CONSULTATION UNDER TOWN AND COUNTRY PLANNING ACT 1990

Application Number	PL/2023/00715/DIS
Address	Bosworth Wood Centre Auckland Drive Smiths Wood Solihull B36 0DD
Proposal	Discharge condition No. 7 following planning approval PL/2022/00491/PPFL
Case Officer	Tristan Hazel

Condition 7 (School Travel Plan)

Figure 4 The Heights Academy; Planning impression showing parking

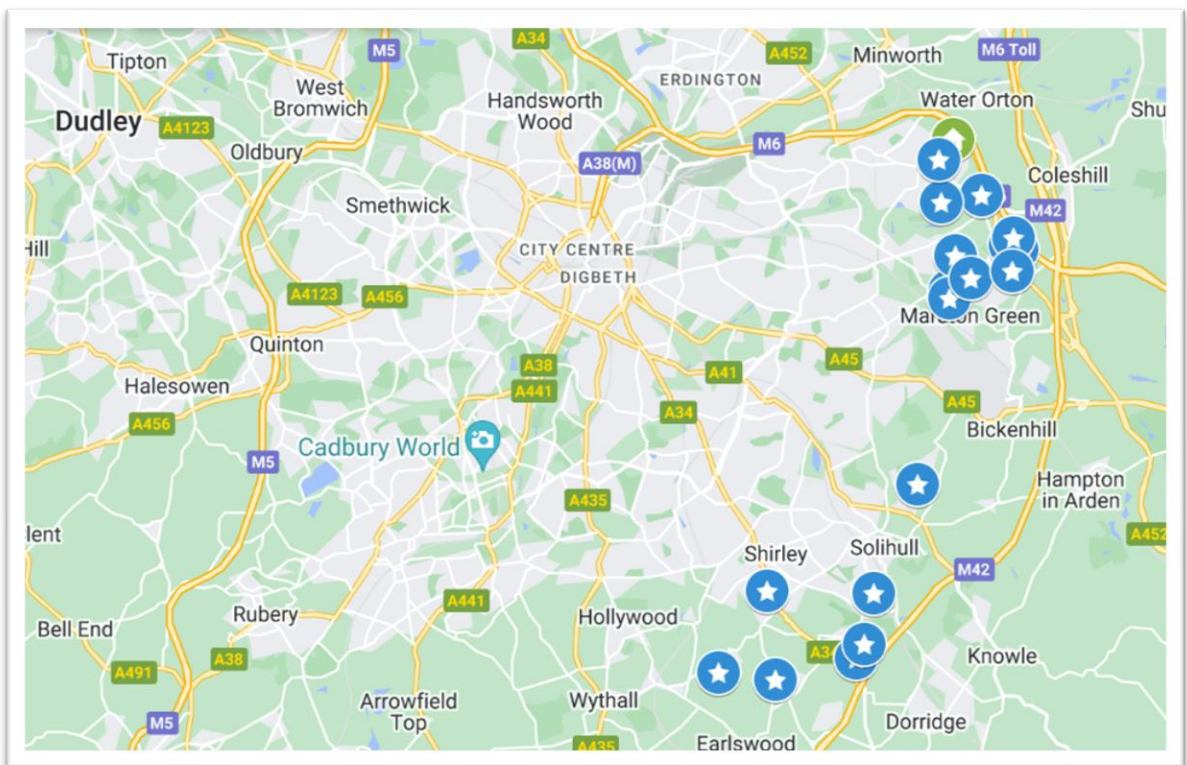
- Plan will need to be entered on to the ModeShift site. Please provide me with DfE number for school so that the site can be created on the system. This will enable monitoring.
- Once ModeShift site is created, all relevant planning documents should also be entered in to the planning section of the Travel Plan.
- Query of 3.1.5 existing layby. Is this to be promoted as drop off area for pupils? If it is, it would be advisable to ask parents to park facing the same way as traffic on the side of the road to ensure least disruption when driving off.
- Point 4.1.4 – will private vehicles dropping off/ picking up be able to enter the school site to do this.
